**Consultation Response from KC,
Lead Local Flood Authority**

2024/92281 Land adj, 17, Whitehall Road West, Birkenshaw, BD11 2LS

Erection of 23 dwellings

Date Responded: 7th February 2025

Title: **General Arrangement 1 of 3 StormTank MPS 32.812 x 7.6 x 1.3 / 0.9 m**

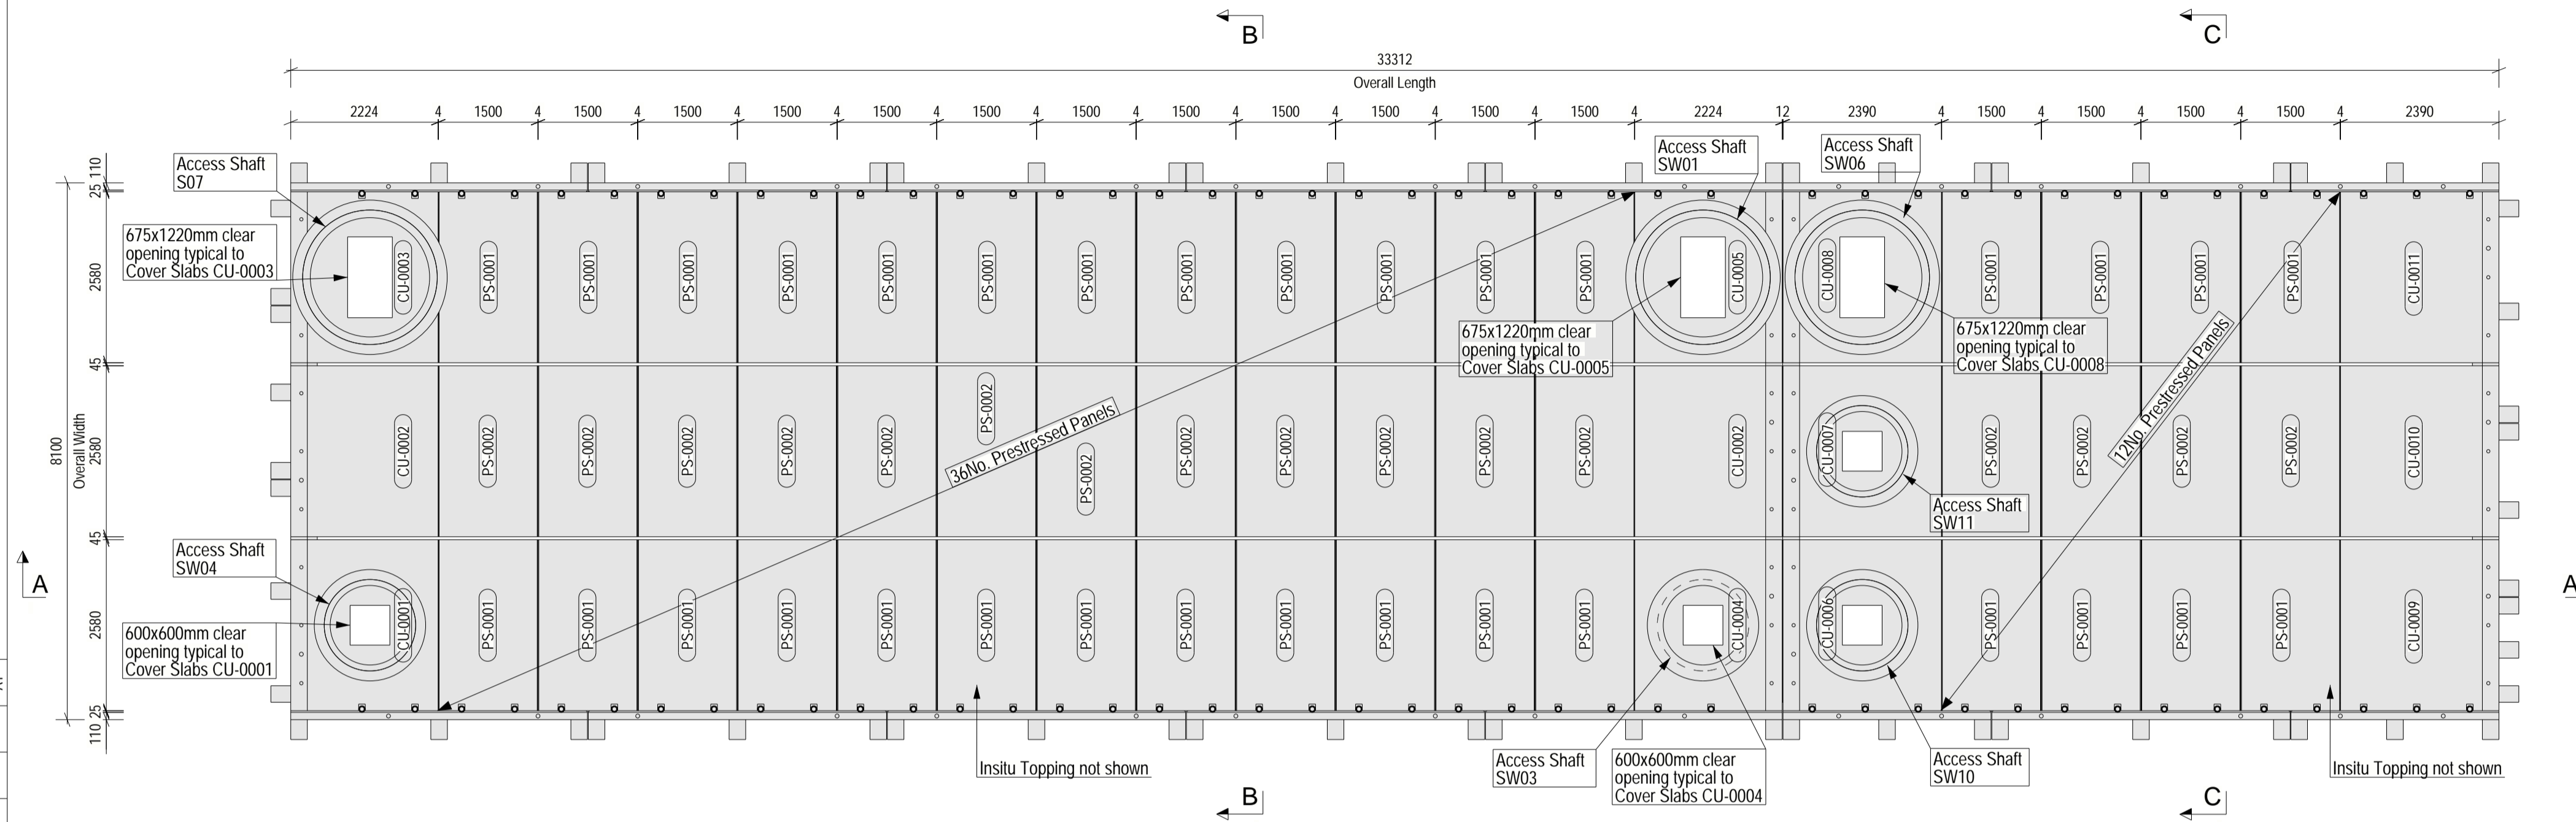
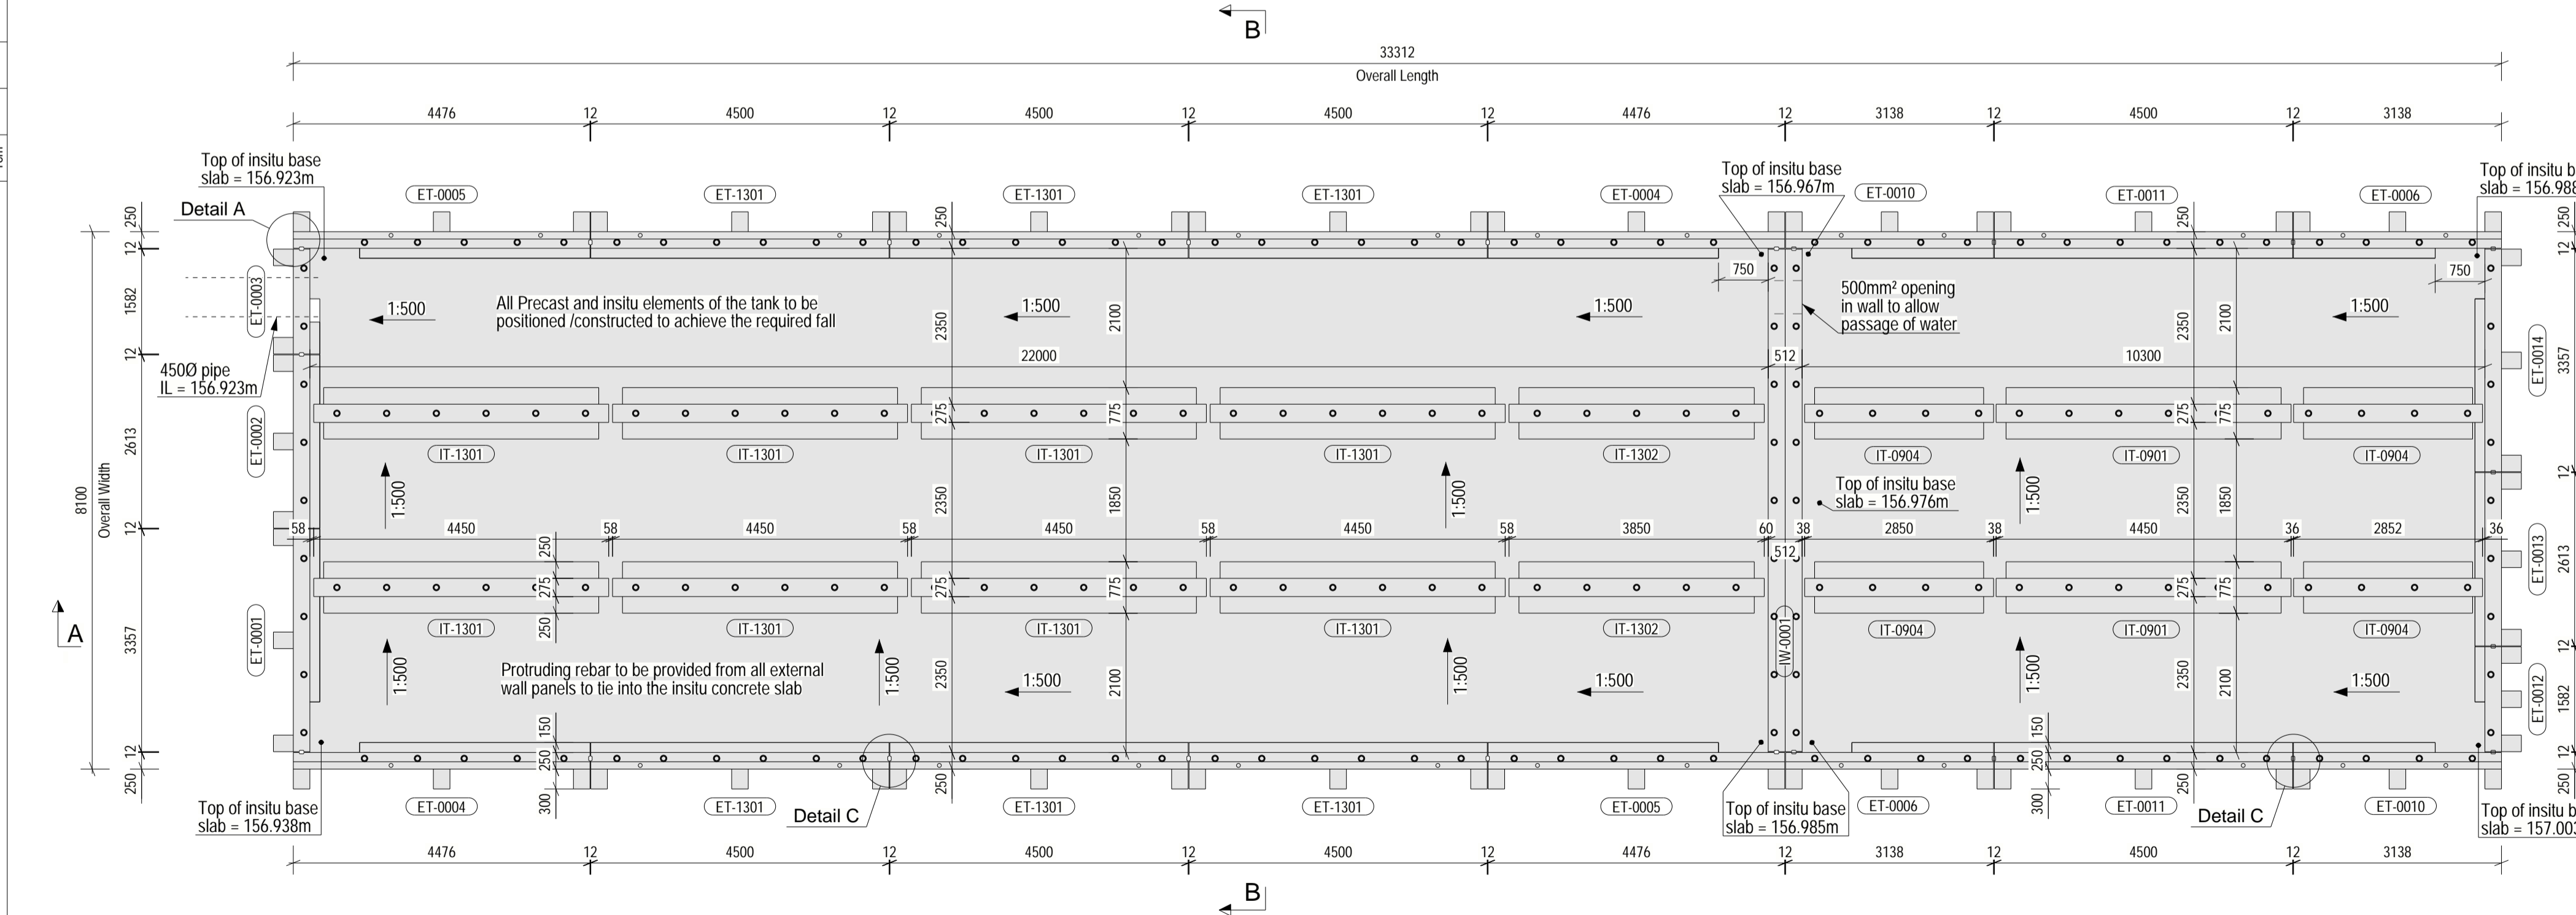
Maintenance manuals mention a Wheolite tank, not the FP McCann type noted on the drainage layout. This can be conditioned but the maintenance manual provided should be removed and not be part of any approval.
